**Wellington North Solar Farm (SSD-8895)  
Request for Additional Information**

I refer to the assessment of the Wellington North Solar Farm (SSD-8895). After careful consideration, the Department is requesting that you provide additional information.

Figure 2-3 Transport Route.

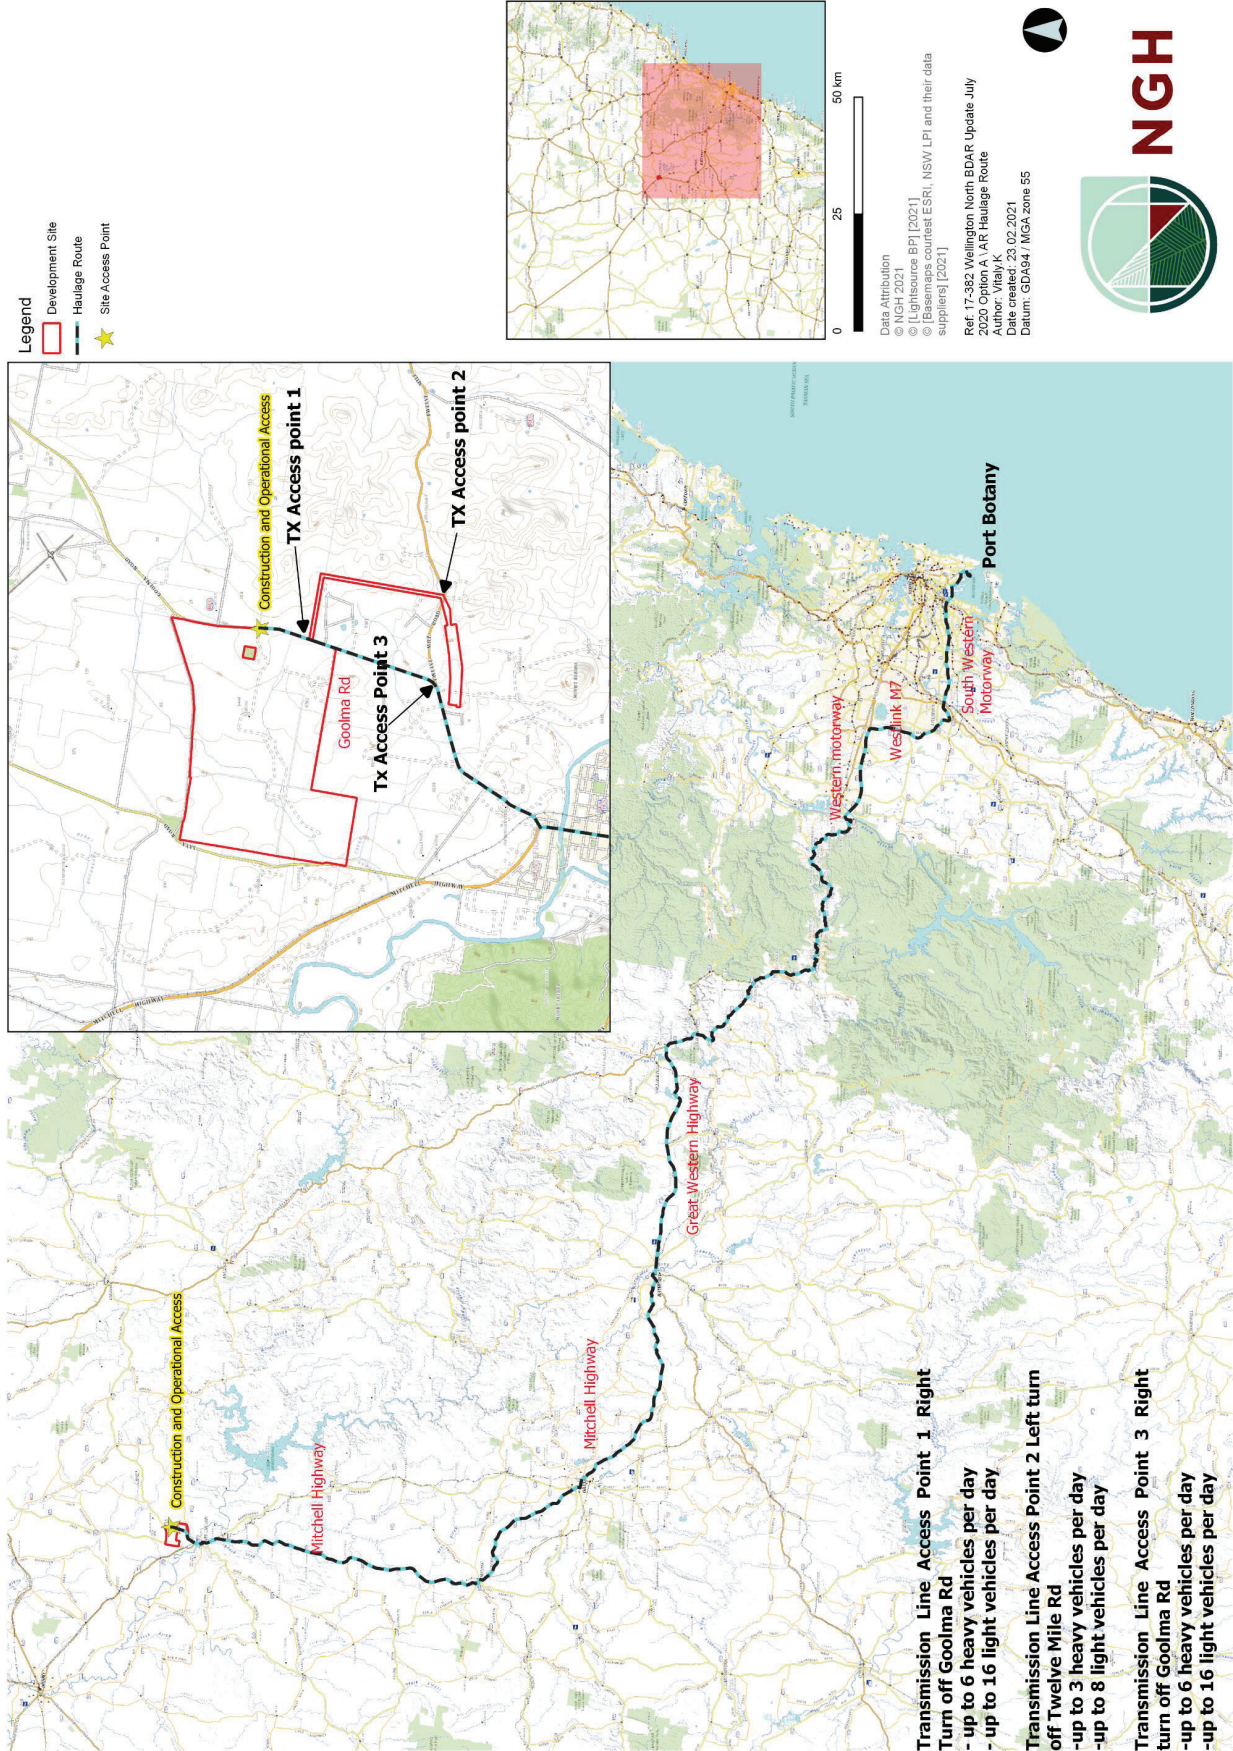
<b>Traffic</b>
<ol style="list-style-type: none"><li>1. Clarify the haulage and transport route proposed for construction traffic and include a figure identifying the proposed route;</li><li>2. If the project related traffic is confirmed to be accessing the site from Mitchell Highway and Cobbora Road, assess transport and traffic impacts associated with the level crossing at the junction of Mitchell Highway and Cobbora Road, in accordance with the Australian Level Crossing Assessment Model (ALCAM) and in consultation with the relevant road and rail authorities;</li><li>3. Provide an assessment of the cumulative traffic impacts associated with Maryvale Solar Farm;</li><li>4. Provide an assessment of construction traffic associated with the proposed transmission line;</li><li>5. Confirm if upgrades proposed for Campbells Lane require widening of the existing road easement and if widening is required, an assessment of the impacts;</li></ol>

Figure 6-1 Final project footprint.

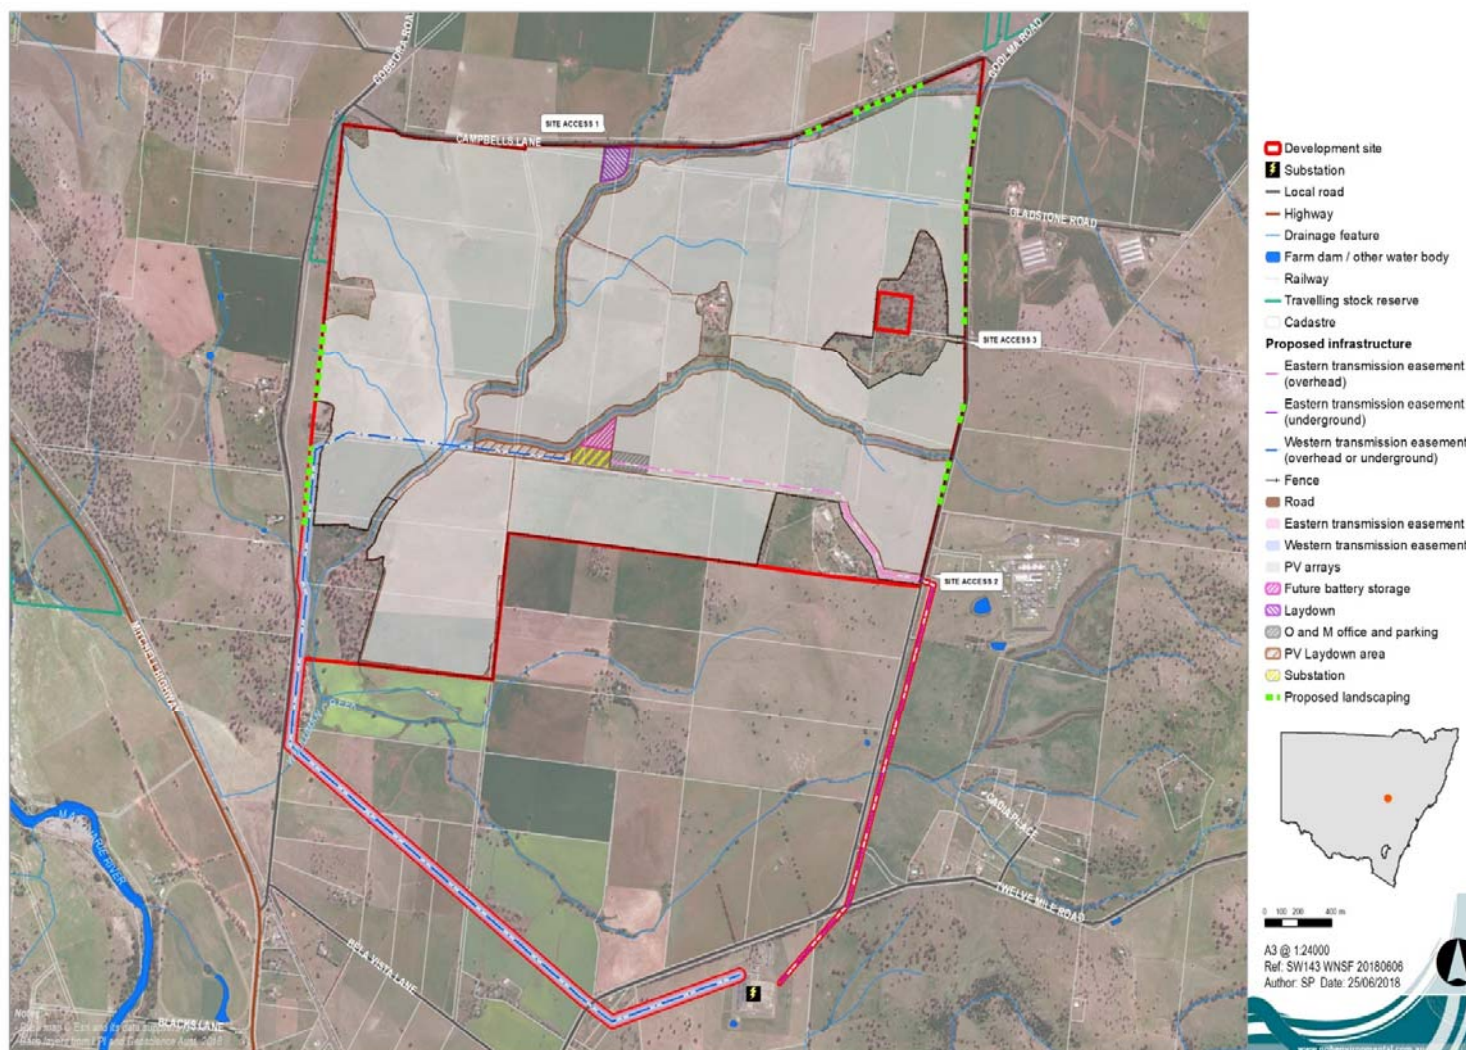
<b>Biodiversity</b>
<ol style="list-style-type: none"><li>6. Provide a figure identifying any areas of proposed vegetation clearance.</li></ol>
<b>Rehabilitation</b>
<ol style="list-style-type: none"><li>7. Provide baseline agricultural data associated with historic crop yields and stocking rates;</li></ol>
<b>Amenity</b>
<ol style="list-style-type: none"><li>8. Provide a figure identifying zones of visual influence for surrounding receivers, including visual heatmapping;</li><li>9. Confirm the duration of any expected noise exceedances at surrounding receivers;</li></ol>
<b>Cumulative Impacts</b>
<ol style="list-style-type: none"><li>10. Provide an assessment of the construction workforce accommodation, including consideration of cumulative accommodation requirements for surrounding developments;</li></ol>
<b>General Information</b>
<ol style="list-style-type: none"><li>11. Clarify the total project area and development footprint, to include the revised transmission line easement;</li><li>12. Update all figures to clarify associated and non-associated receivers; and</li><li>13. Confirm that any additional water can be sourced from an appropriately authorised and reliable supply.</li></ol>
